Site Address: Holly Cottage Yapton Road Middleton-On-Sea PO22 6DT

Description of Works: New vehicular access.

WEST SUSSEX COUNTY COUNCIL CONSULTATION

TO:	Arun District Council FAO: Samantha Allen
FROM:	Highways, WSCC
DATE:	1 st August 2018
LOCATION:	Holly Cottage, Yapton Road, Middleton-on-Sea, Bognor Regis, PO22 6DT
SUBJECT:	M/83/18/HH New vehicular access.
RECOMMENDATION:	☒ Advice ☐ Objection ☐ Modification ☐ No Objection ☒ More Information ☐ Refusal
S106 CONTRIBUTION TOTAL:	£N/A

DRAWING
**SITE PLAN
LOCATION PLAN**
DRAWING No
264/01

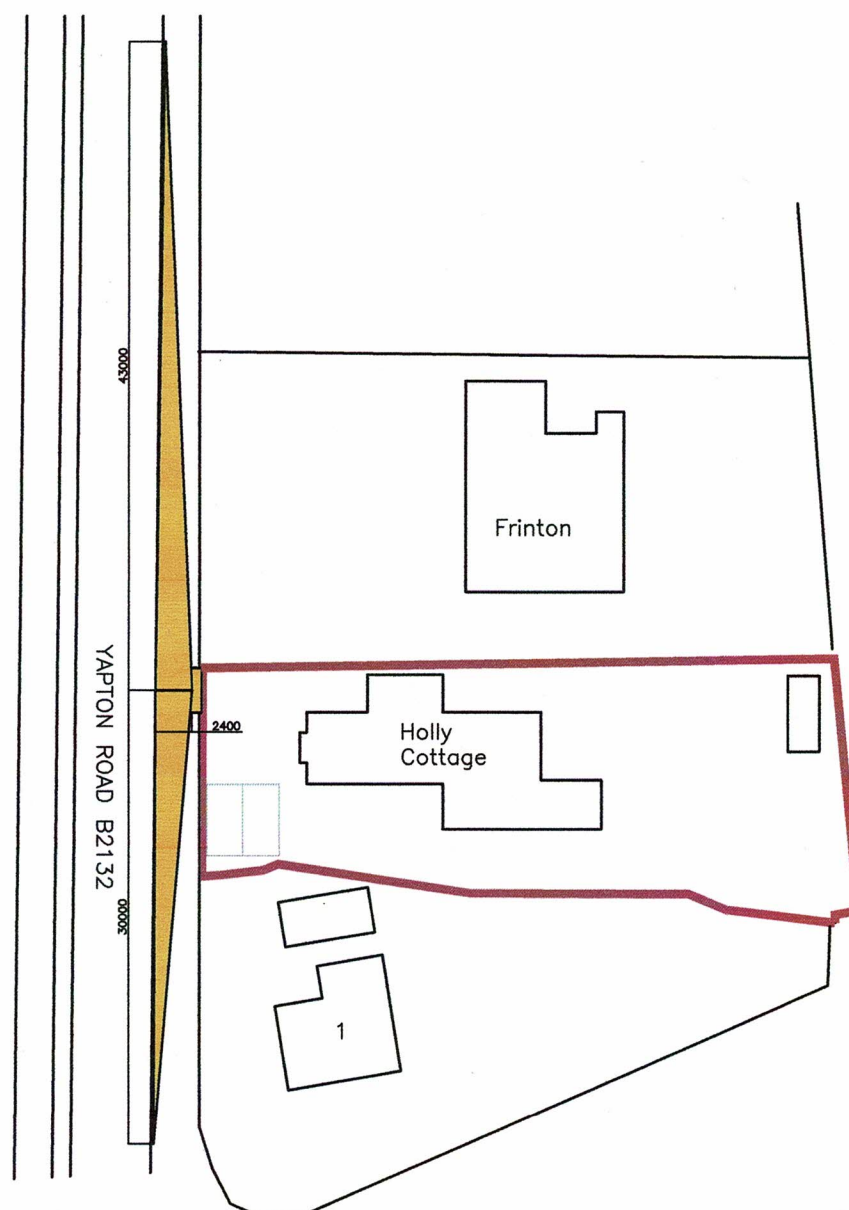
A 3 metre wide vehicle crossover is proposed across the existing highway verge to facilitate vehicle access to parking on the frontage.

From an inspection of local and WSCC mapping the property appears to already be served by a vehicle access on its boundary with Elmer Road ('C' classified and subject to 30 mph speed restriction). The applicant should clarify why a secondary access is proposed and should be aware that a licence for a crossover in this location may not be granted by the Arun Area Engineer due to their policy on granting a licence for secondary accesses due to existing parking pressures and loss of on-street parking provision for neighbouring residents.

The proposed plan indicates two new car parking spaces on the frontage. These meet the required dimensions of 2.4m by 4.8m with 6 metre clear space rear of these to enable a turn on site.

Vehicular visibility has not been demonstrated from the proposed access on to Yapton Road. Manual for Streets (MfS) sets out a stopping sight distance (SSD) requirement of 43m for 30 mph speeds. Splays should be taken from 2.4m back into the centre of the proposed access to represent the position of a driver and should extend to the nearside

carriageway edge. From an inspection of WSCC mapping a splay in excess of this is achievable in the leading direction (north), entirely within the public highway. To the south the verge and neighbouring boundary tapers in, providing less highway boundary land to facilitate a splay. From an inspection of WSCC mapping approximately 25m is achievable to the south, taken to a 1m offset from the carriageway edge. This equates to a SSD speed of 20mph. The LHA appreciate vehicle speeds may be lower than the posted limit in this location due to proximity of the mini roundabout. Nevertheless, no evidence has been provided demonstrating achievable splays or that these achievable splays correspond with actual vehicle speeds in this location. The applicant should demonstrate suitable vehicle visibility splays and consider carrying out a 7 day Speed Survey to ascertain the 85th percentile speeds along Yapton Road in this location to ensure that the achievable splays are in accordance with actual vehicle speeds. These should be placed at the extent of the achievable visibility splays and at the central point of the access point, where possible.
